**Consultation Response from KC,
Highways Development Management**

2026/92207 Percy Shaw House, Queen Street South, Huddersfield, HD1 3BZ

**Discharge of details reserved by condition 4 (parking area) on previous permission 2026/91335
for change of use of building from education (F1) to office (E(g)(i))**

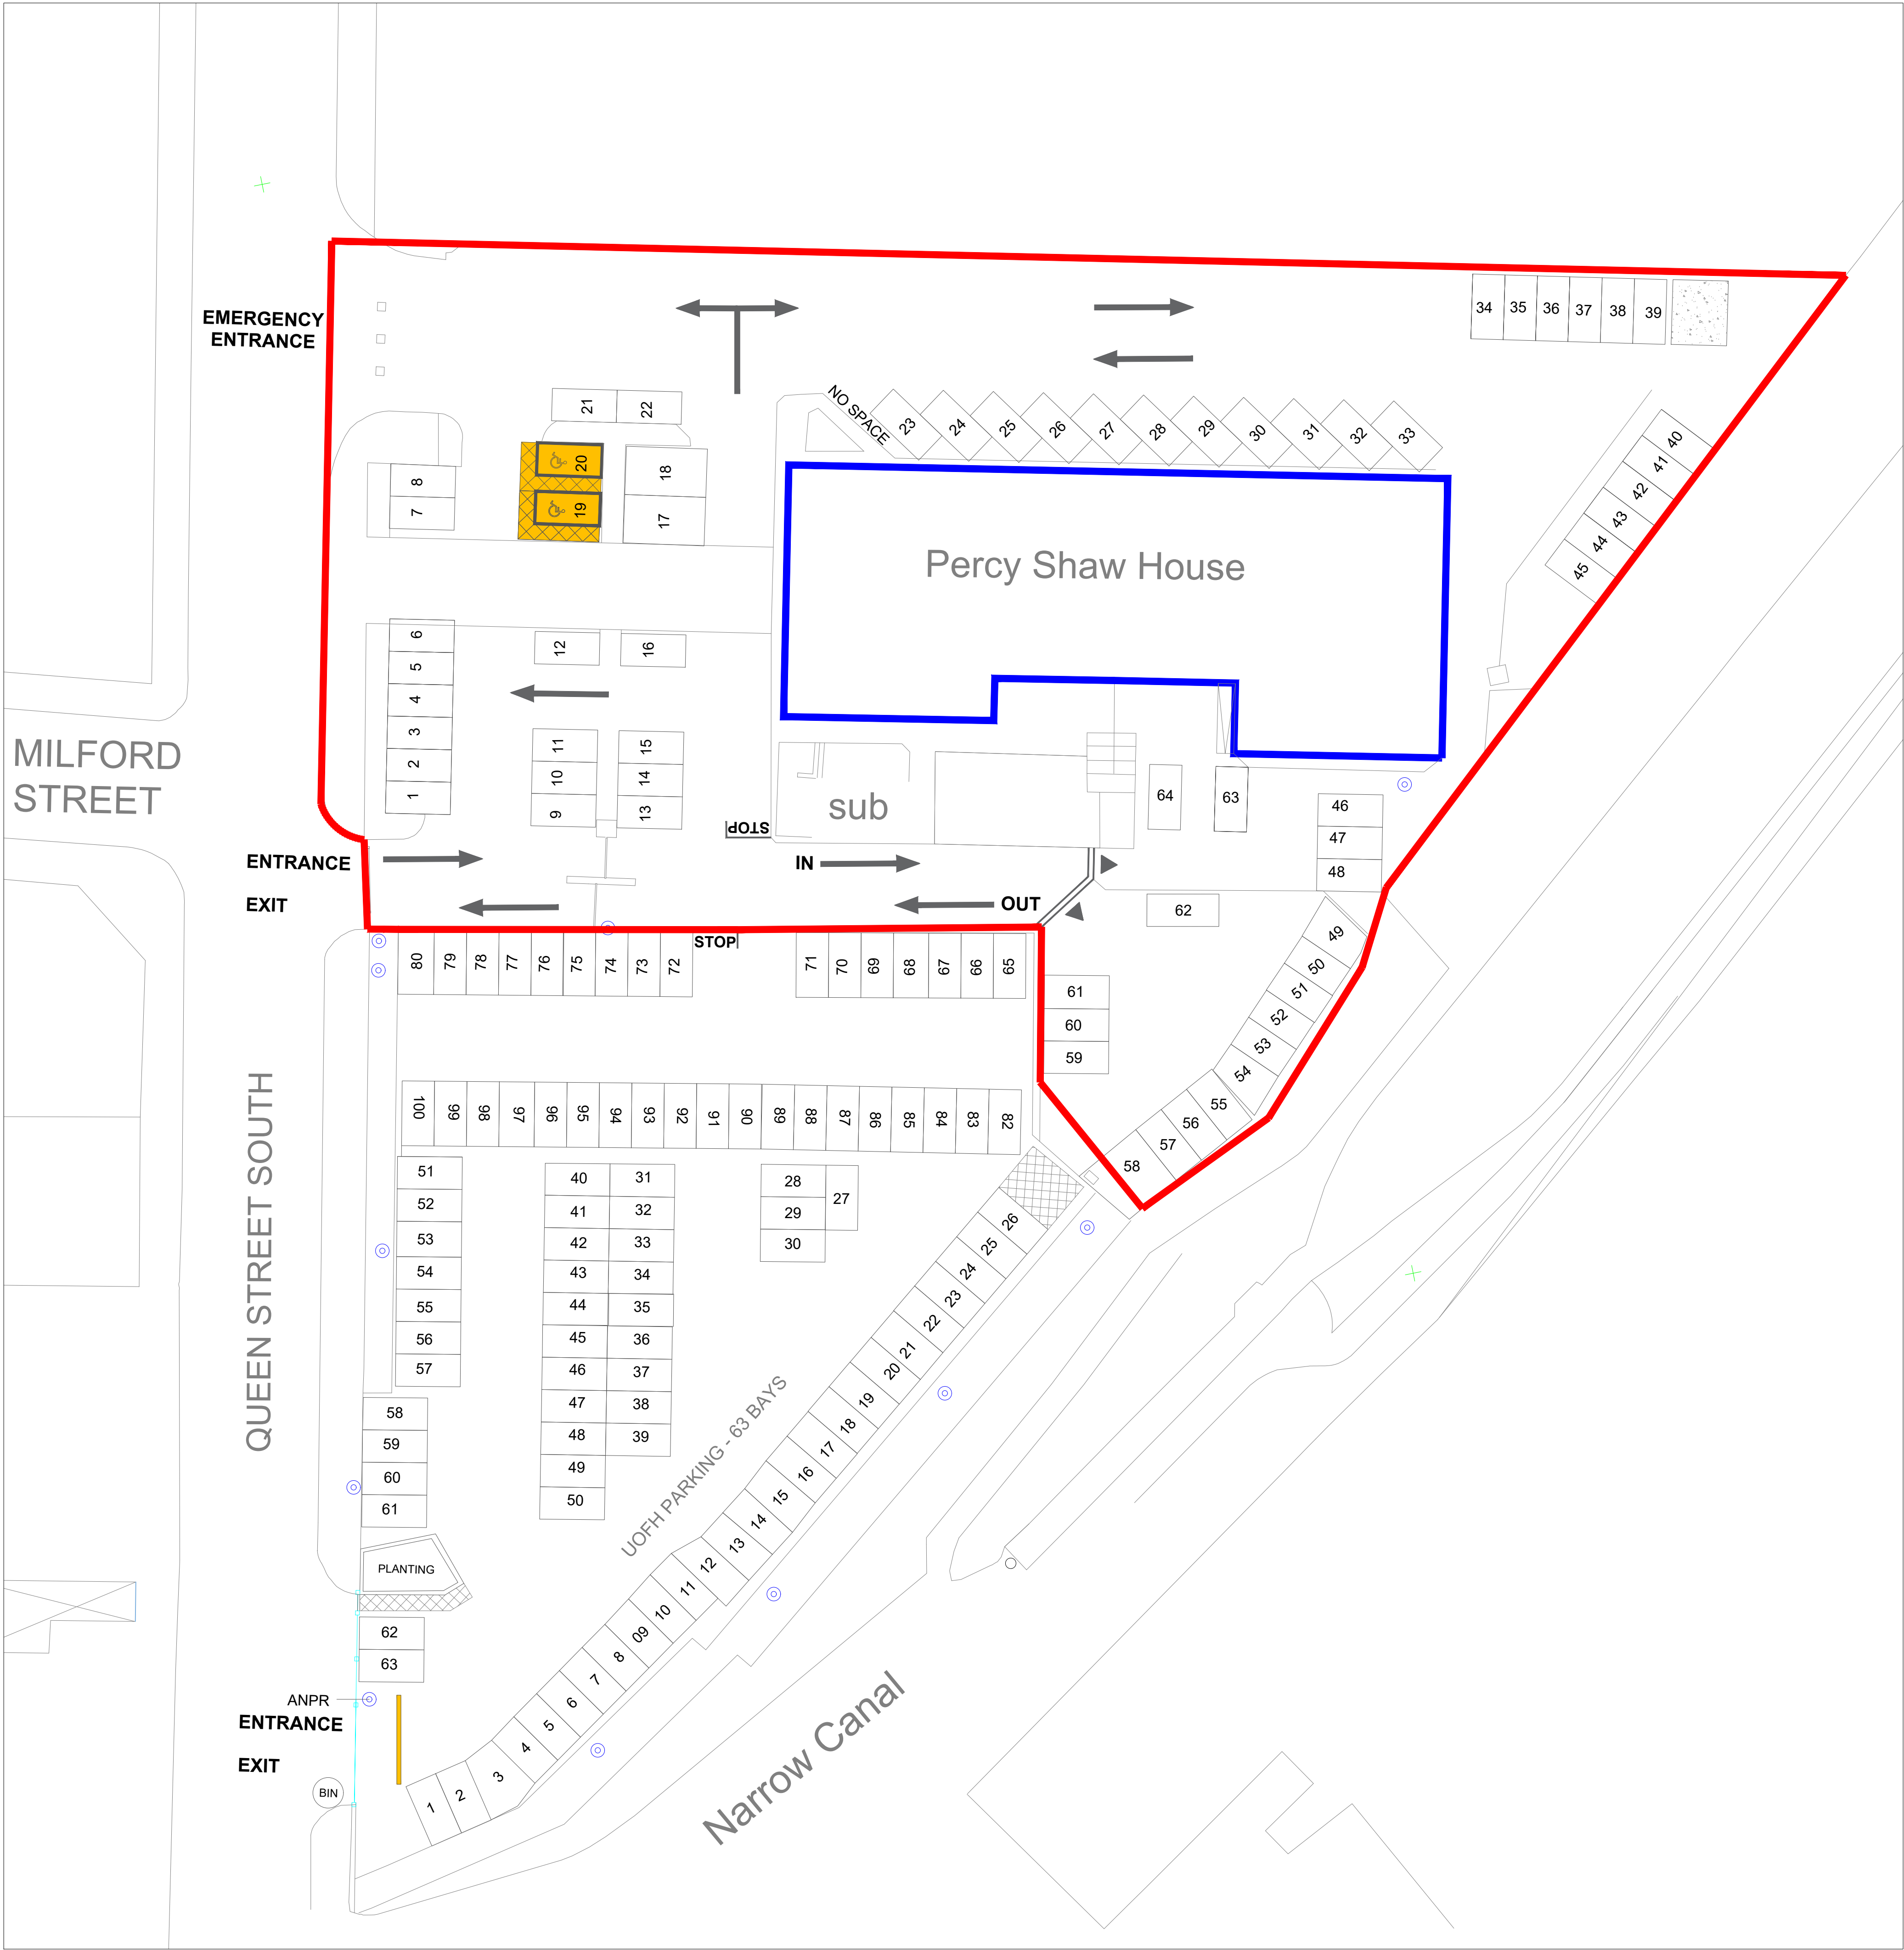
A parking plan has been submitted in accordance with the requirements of this condition showing directional arrows around the main car parking area, with in and out markings for the rear parking area.

The information submitted is therefore acceptable and condition 4 can be discharged.
